Norfolk County Council

ISH2 post-hearing submission

Norwich to Tilbury (EN020027)

Deadline 4 – 12 May 2026

Image E.8 Total vehicle distribution in PARs - Norfolk (worst case peak hour) – PAR 8

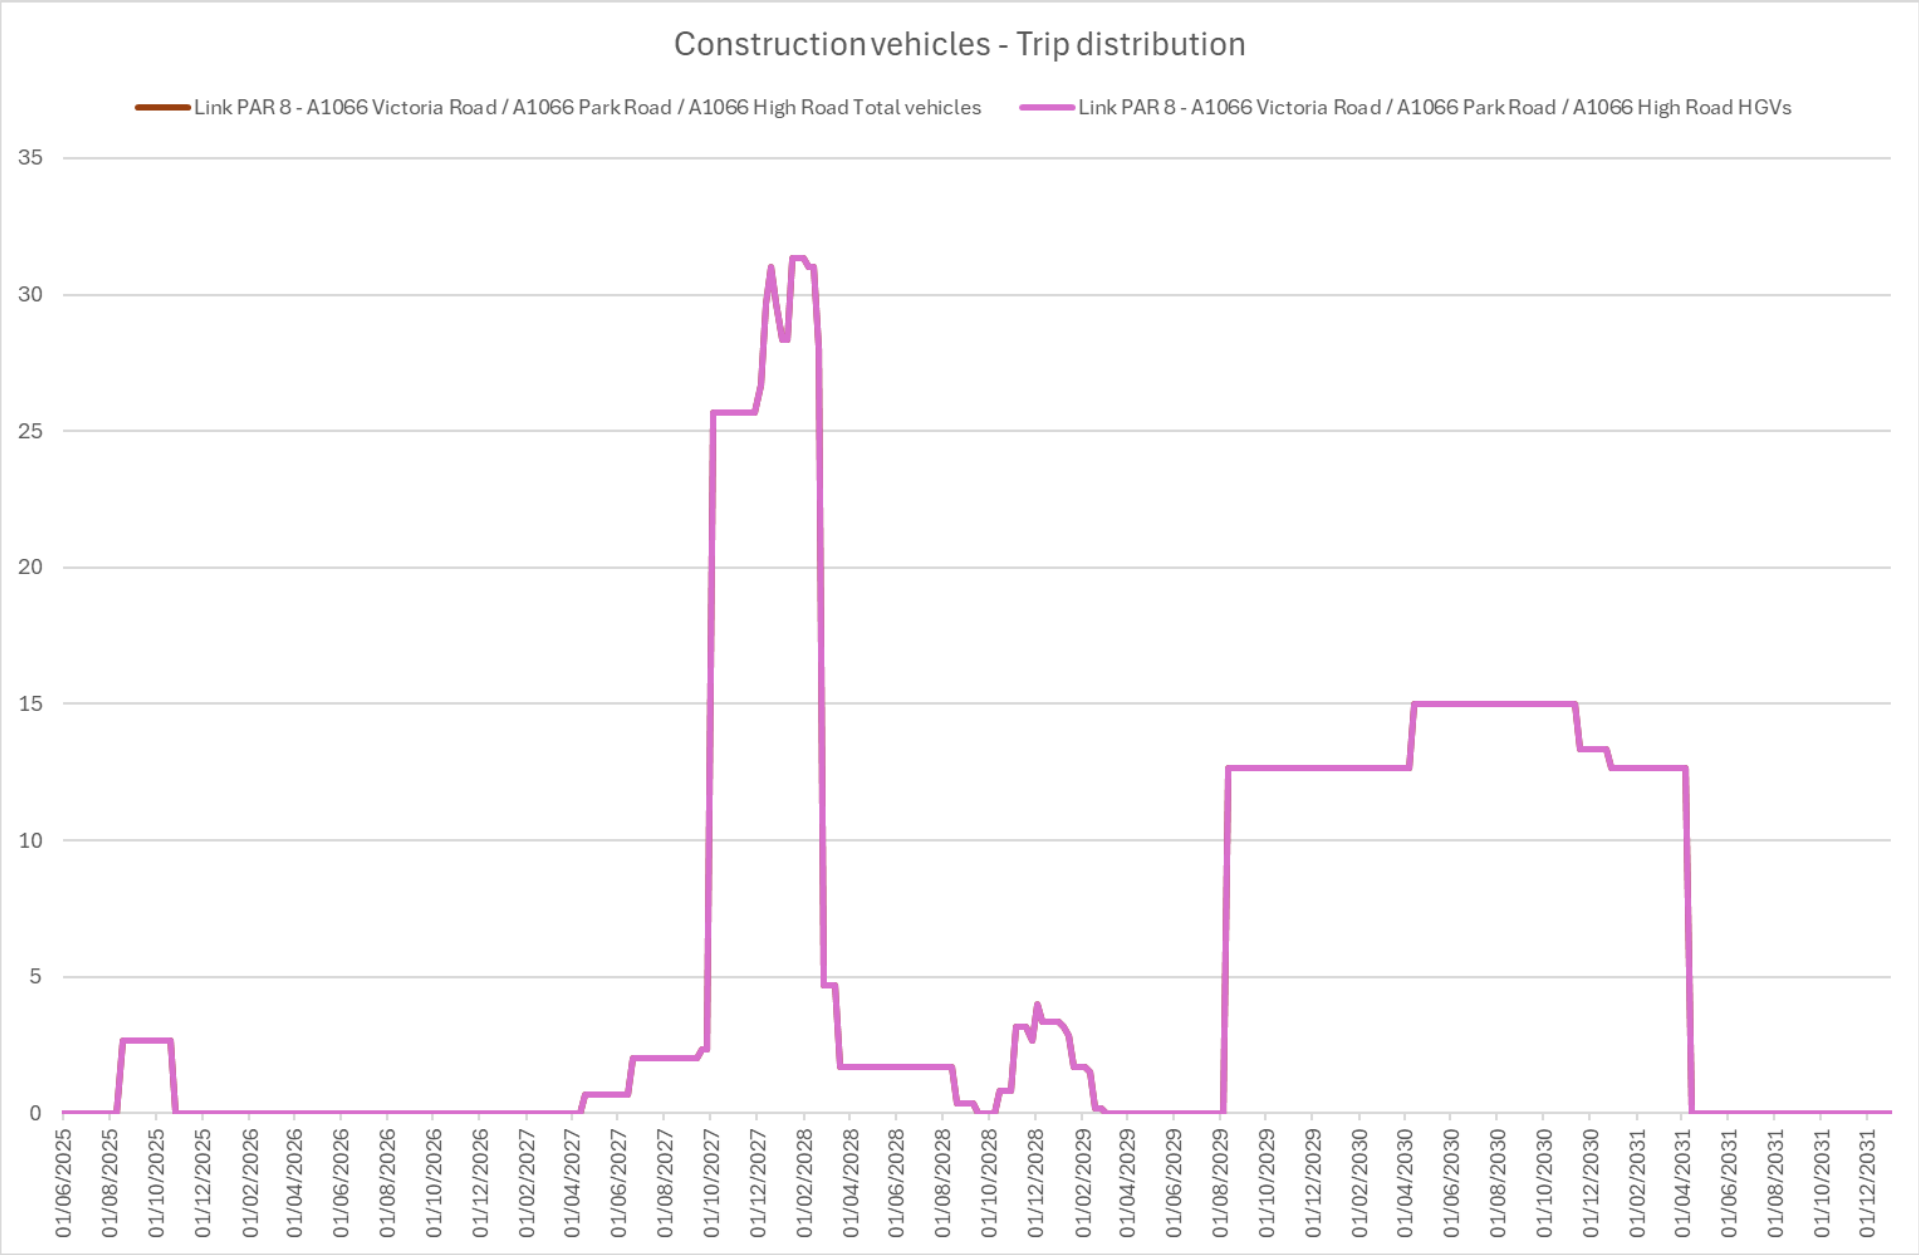
| Issue | NCC comment |
|---------------------------------|--|
| 11 Traffic and transport | <p><u>11.1 Baseline, modelling and future monitoring</u></p> <p>Under the agenda point concerning junction modelling, the ExA raised an issue relating to the split of traffic for Thetford and Diss. NCC still has concerns regarding the split of traffic and movements going through Diss. The applicant has committed to providing further modelling to allow us to examine the impact in greater detail but we have not received any further information to date. NCC has a meeting with</p> |

| Action Point | NCC comment |
|--|--|
| <p>38</p> <p>Diss to Thetford (PARs 8 and 9)</p> <p>Norfolk County Council to provide further comments and an update on discussions.</p> | <p>In Table 4.26 of their response to local impact reports [REP2-030] the applicant claims that there is no 'step change' in the performance of junctions on PAR 8. Nevertheless, their junction modelling does show deterioration in performance by overloading junctions past their capacity. The applicant has committed to providing further modelling to allow us to examine the impact in greater detail but we have not received any further information to date</p> <p>NCC has a meeting with the applicant on Wednesday 13 May to discuss highway matters in detail. A further update will therefore follow in the next update to the statement of common ground.</p> |
